CITY OF ALBUQUERQUE

October 12, 2018

**Re: TRU by Hilton Hotel
Erosion and Sediment Control Plan
Engineer's Stamp Date 10-4-18 (F17E044C)**

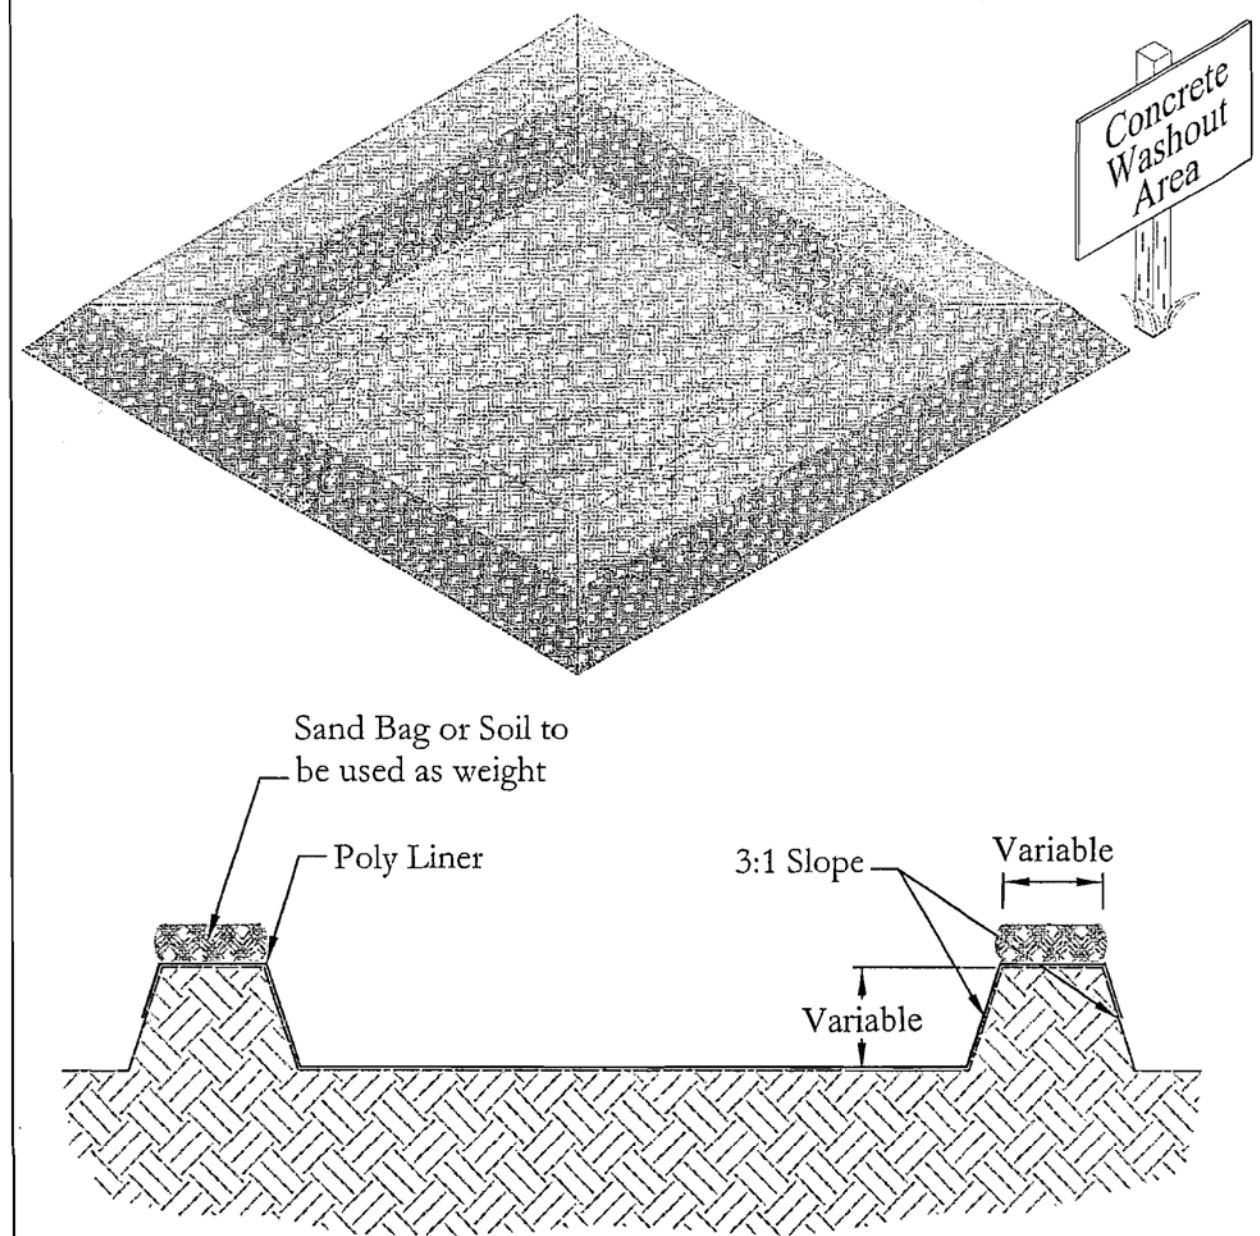
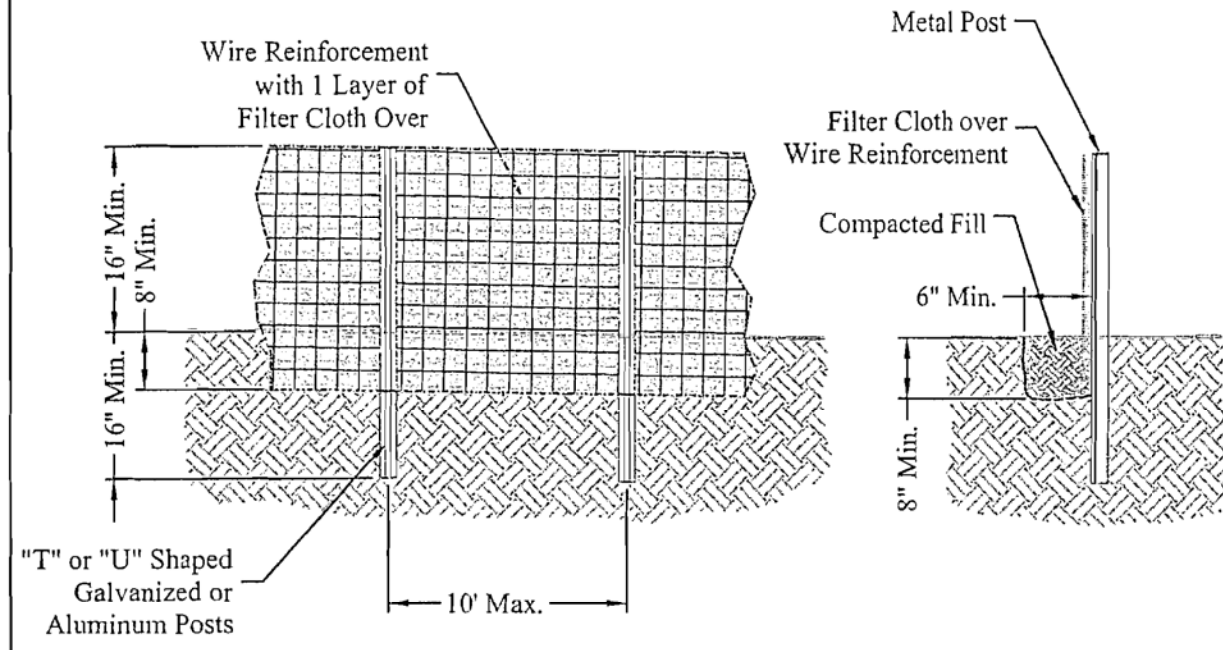
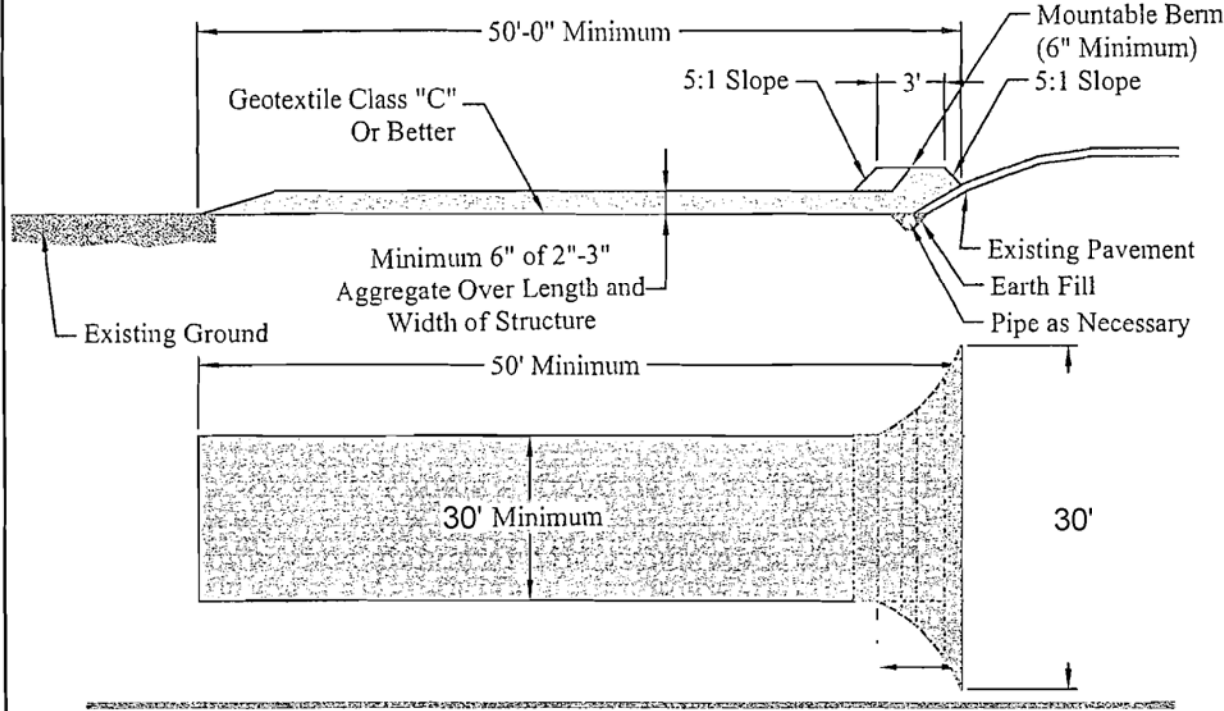
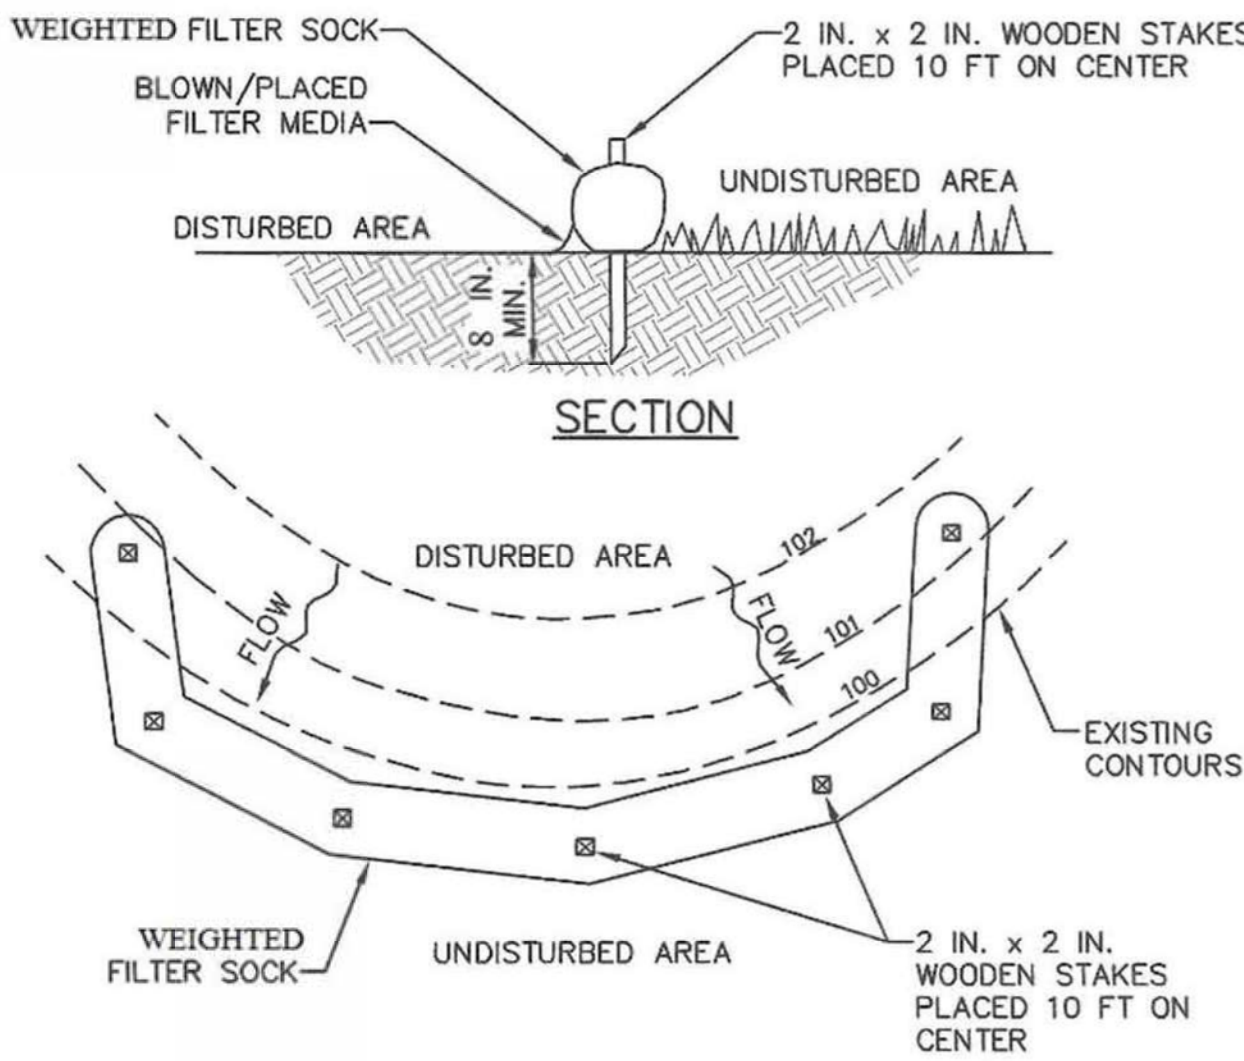
1. The mulch sock sediment BMP is to be replaced with silt fence along the western edge and along the southern edge from the southwest corner of the project to the west side of the stabilized construction entrance.

This is due to proposed onsite grades being 4 to 7 feet higher than the adjacent grade.

Please revise the plan and resubmit it electronically, only.
